Southampton to London Pipeline Project

Responses to ExA's Further Written Questions -
Traffic and Transport (TT)

Application Document: 8.45

Planning Inspectorate Reference Number: EN070005

Drawing title
**PROVISIONAL FARNBOROUGH
PLAN & SECTION OF
RINGWOOD ROAD DIRECTIONAL
DRILLING TC 020**

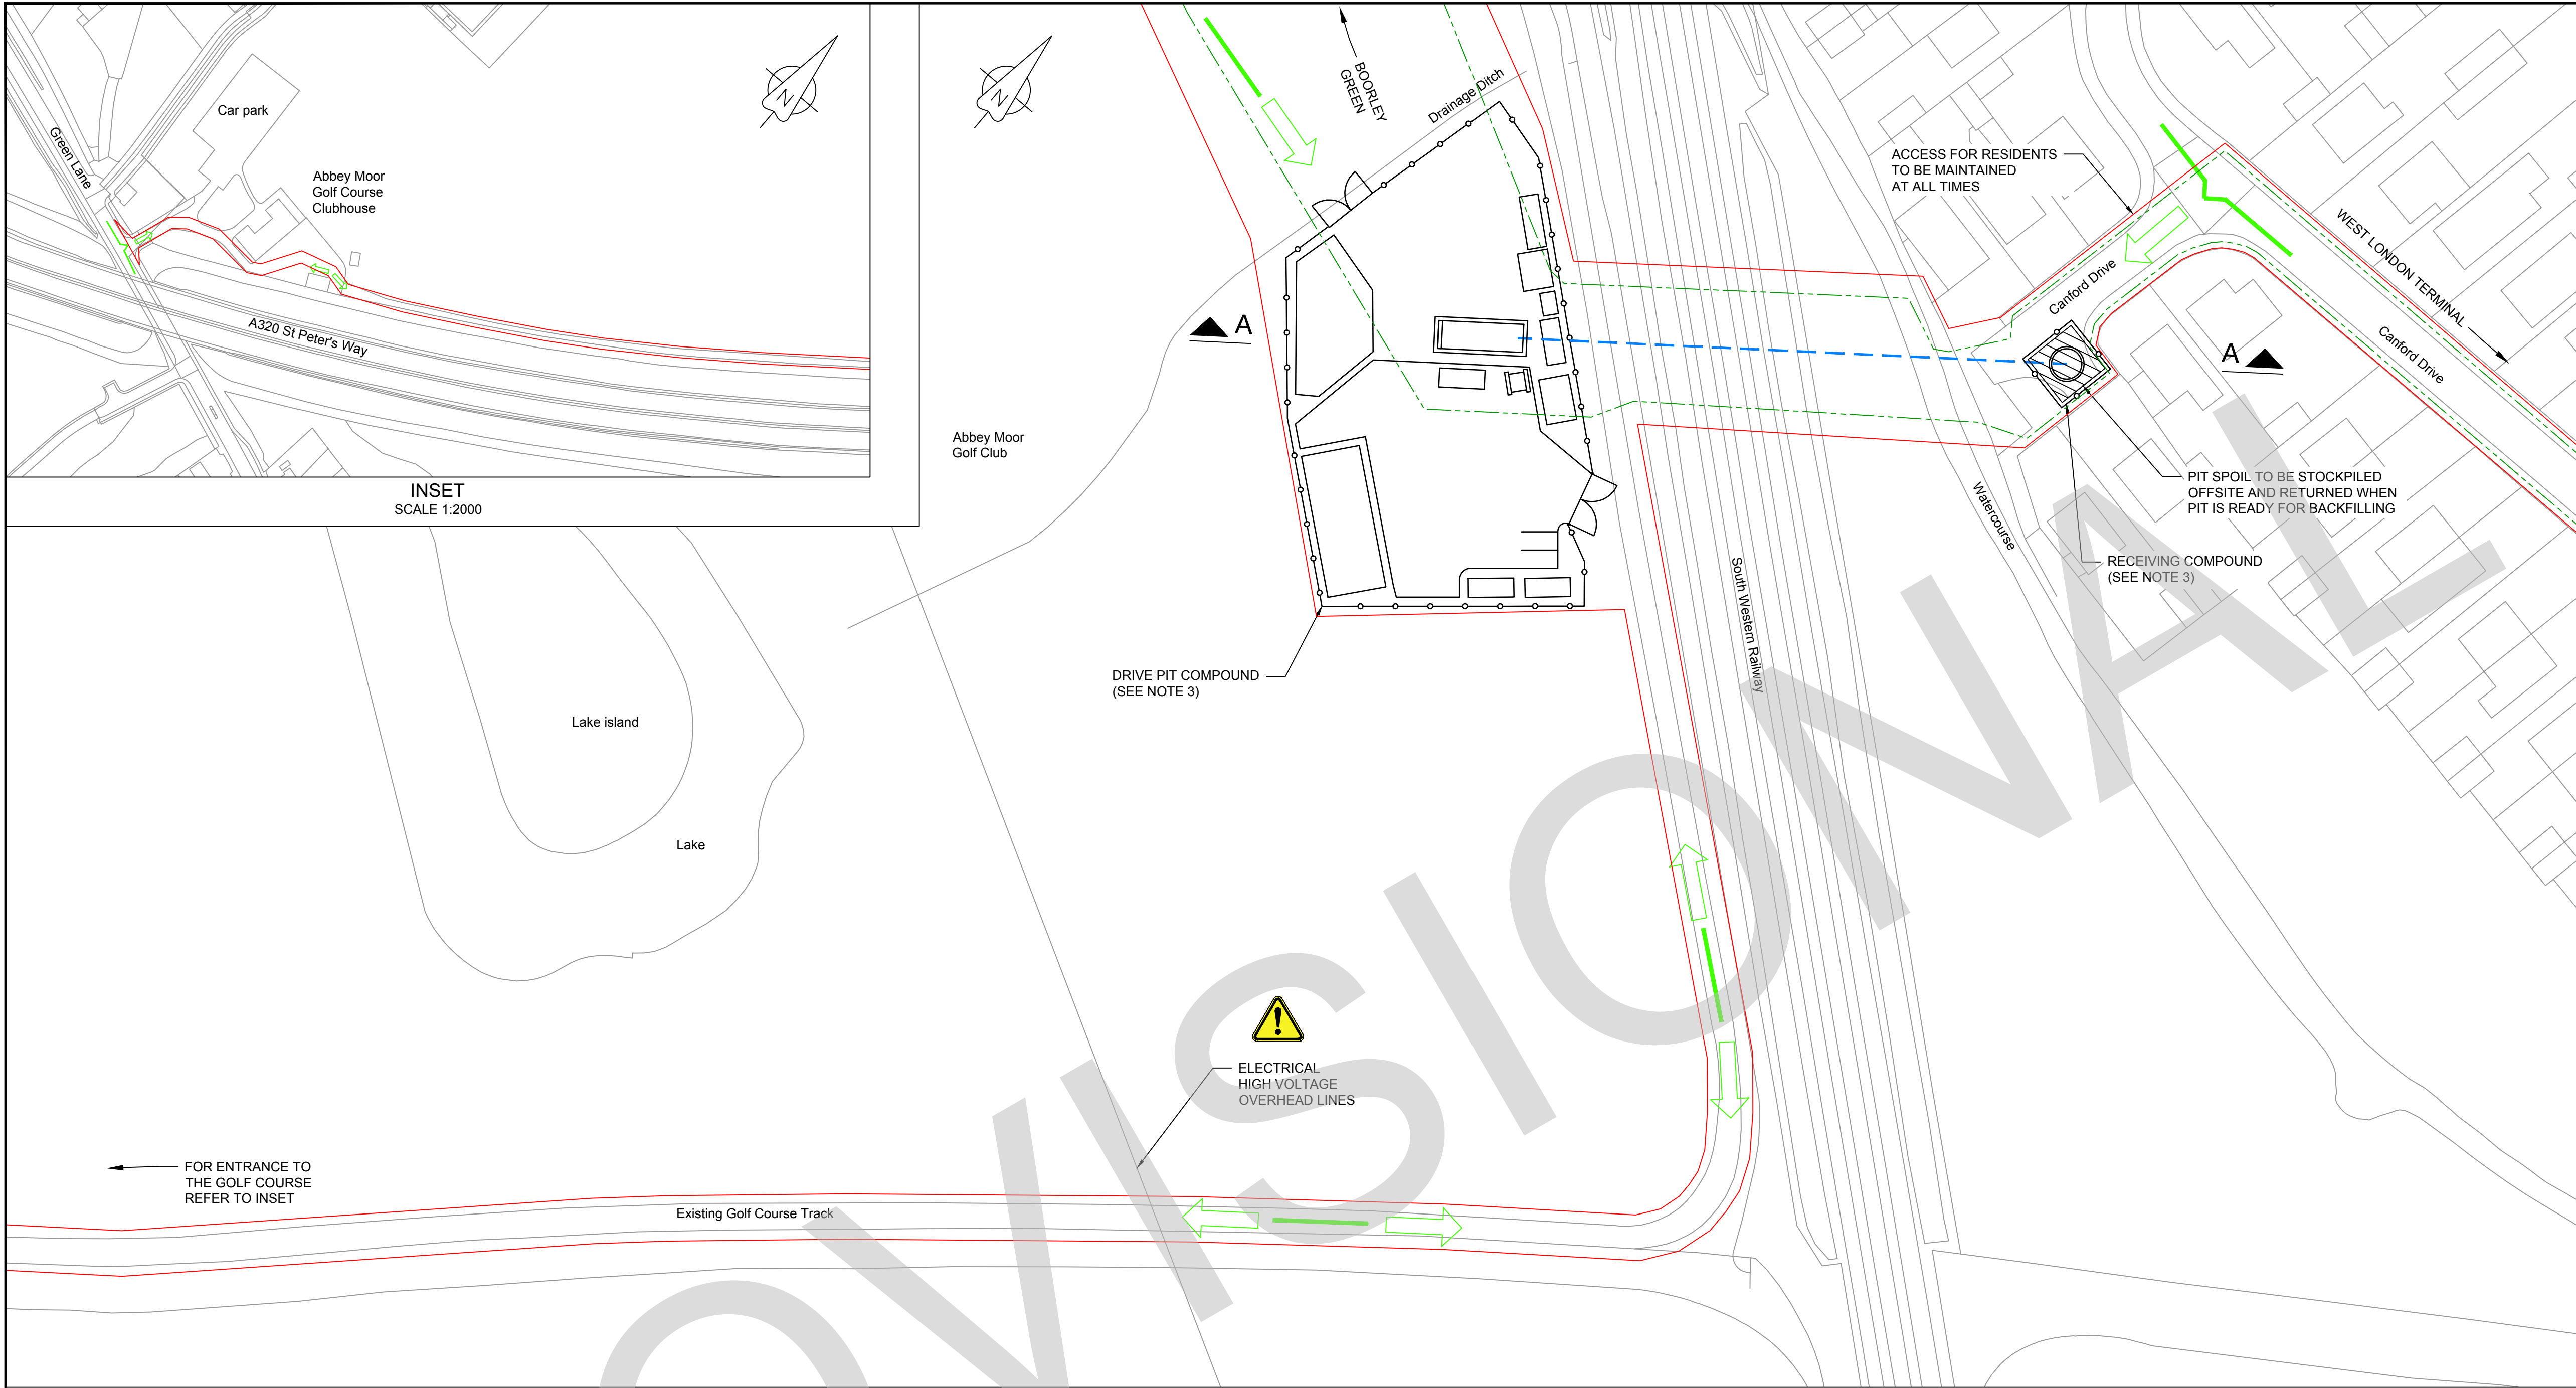
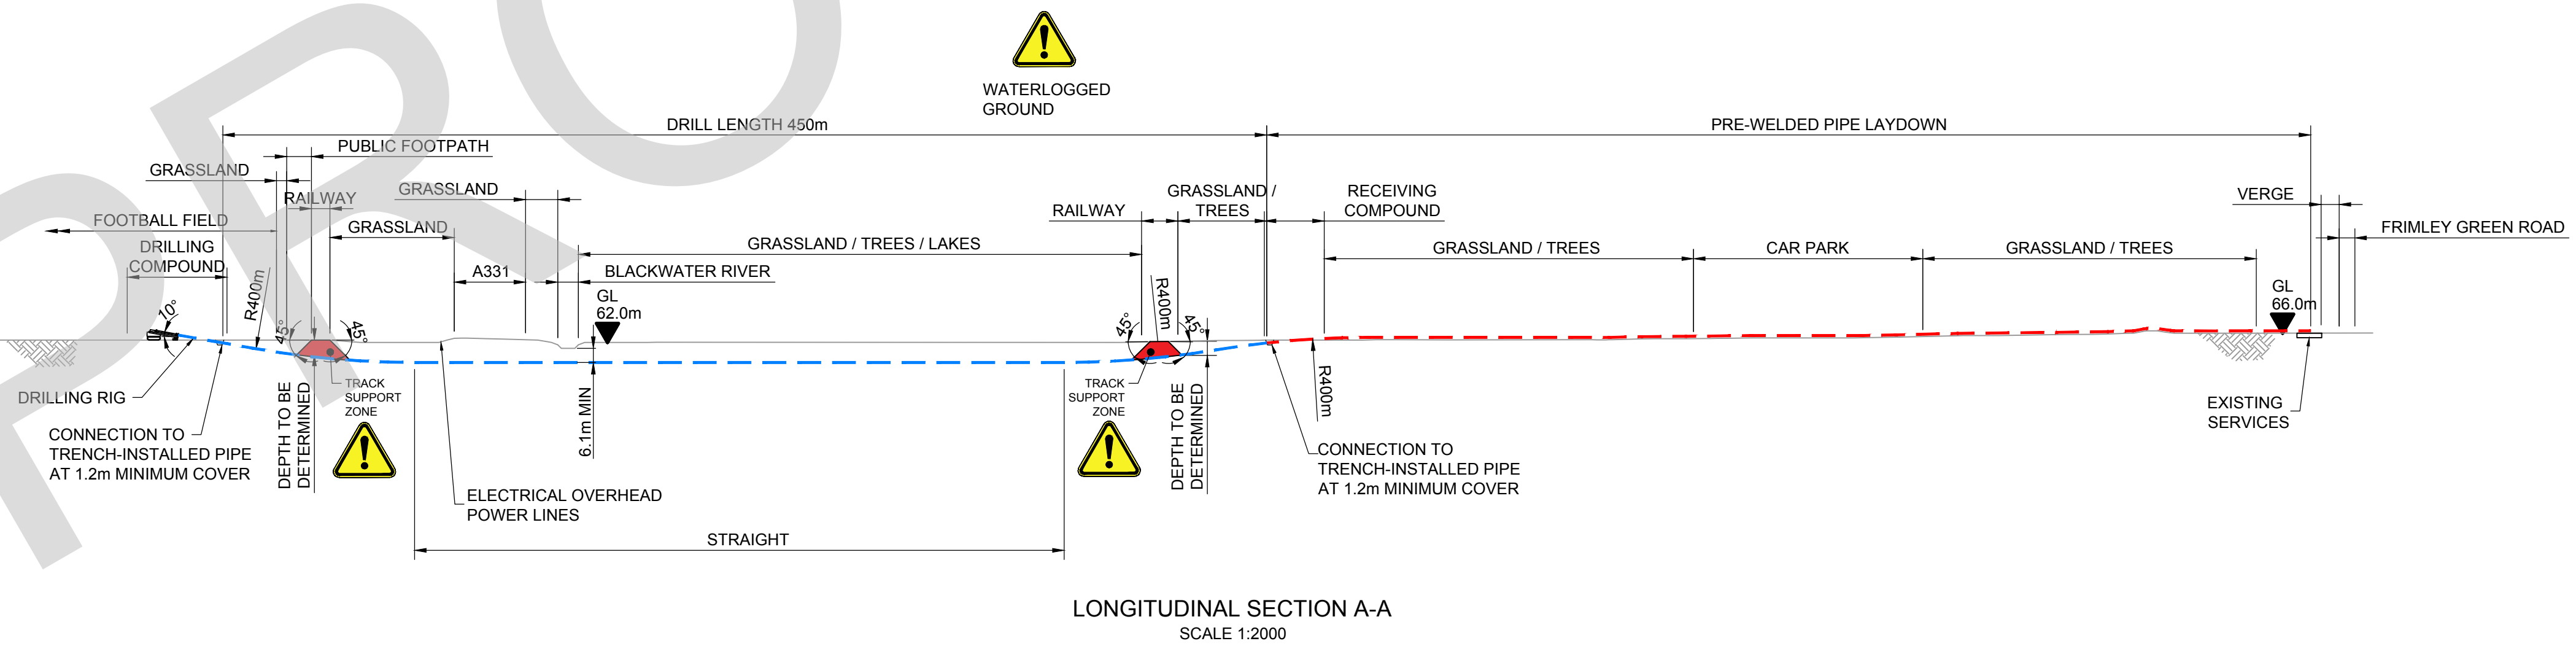
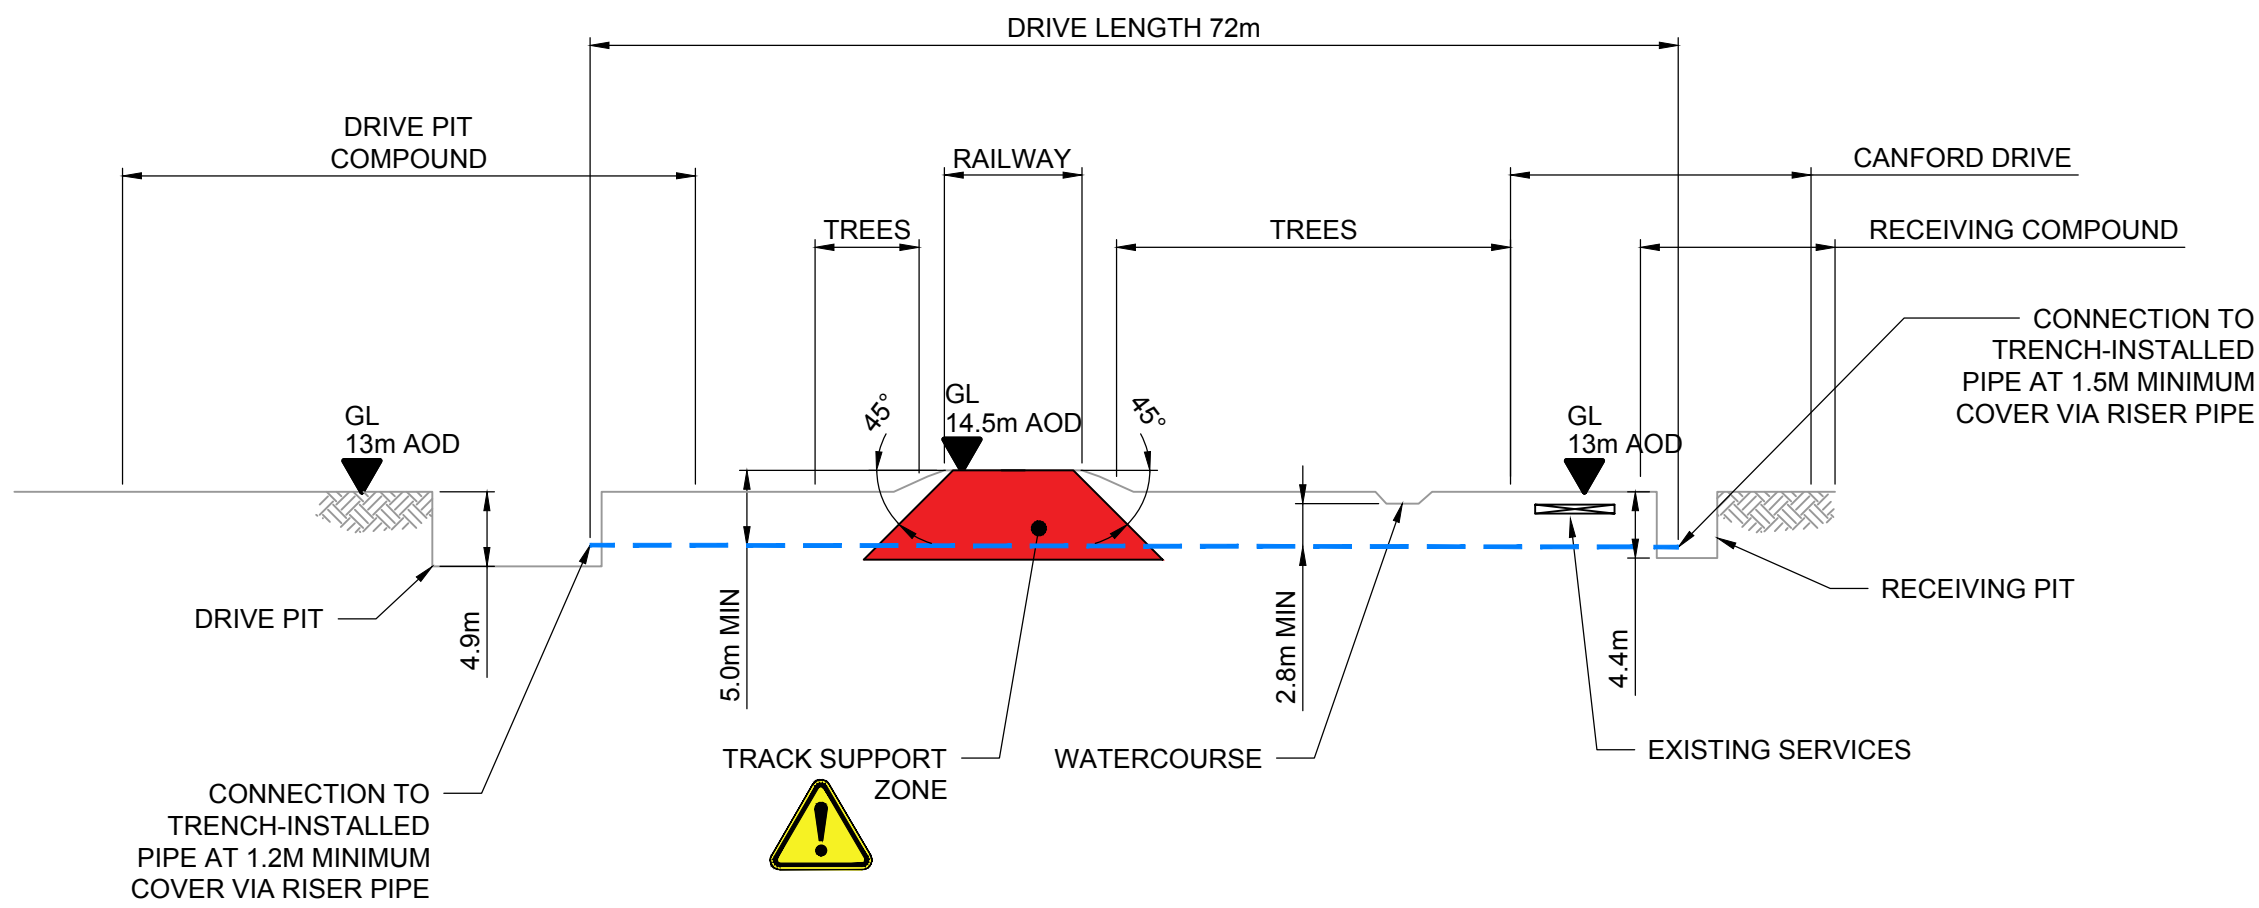
TT.2.5	<p>On sheet TC-020 of the submitted crossing drawings [REP3-026], there is a note indicating that it may be necessary for pre welded pipe to be strung out across Frimley Green Road that would require a closure of Frimley Green Road.</p> <p>For the Applicant:</p>	<p>1.1 The Applicant would only consider this approach as a last resort. There are a number of mitigation measures which would need to have been exhausted to have arrived at a full road closure as the solution.</p> <p>1.2 Hierarchically:</p> <ul style="list-style-type: none"> • The Applicant would avoid the need for a long Horizontal Directional Drill (HDD) string. • The Applicant would consider installing a temporary below-highway culvert which would allow the HDD string to be pulled through that highway, allowing the highway to remain operational. (The culvert could be installed using traffic management to Frimley Green Road).

ExQ2	Question:	Applicant response to Question:
	<p>i) In the event of it being required confirm the estimated duration of this possible closure and whether the closure has been discussed and agreed with the Surrey County Council.</p> <p>For Surrey County Council:</p> <p>ii) Given expressed concern about congestion effects of works impact on Frimley Green Road confirm that this possible closure has been agreed, along with any necessary diversion routes that may be needed.</p>	<ul style="list-style-type: none"> • The option/solution of closing the road and laying the pipe over the highway. <p>1.3 In terms of the duration, the Applicant anticipates that, in the unlikely event that it were required, Frimley Green Road would be closed for potentially 2/3 days. However this would be a partial closure only under traffic management. The works being undertaken would be the welding, testing and coating, along with all associated inspections and testing required to the replacement pipe.</p> <p>1.4 The Applicant has discussed this approach with Surrey County Council, and in principal it was agreed, but the Council would, as part of the permit application, review the duration and timing of the closure and would be in a position to place conditions on the permit being approved.</p>
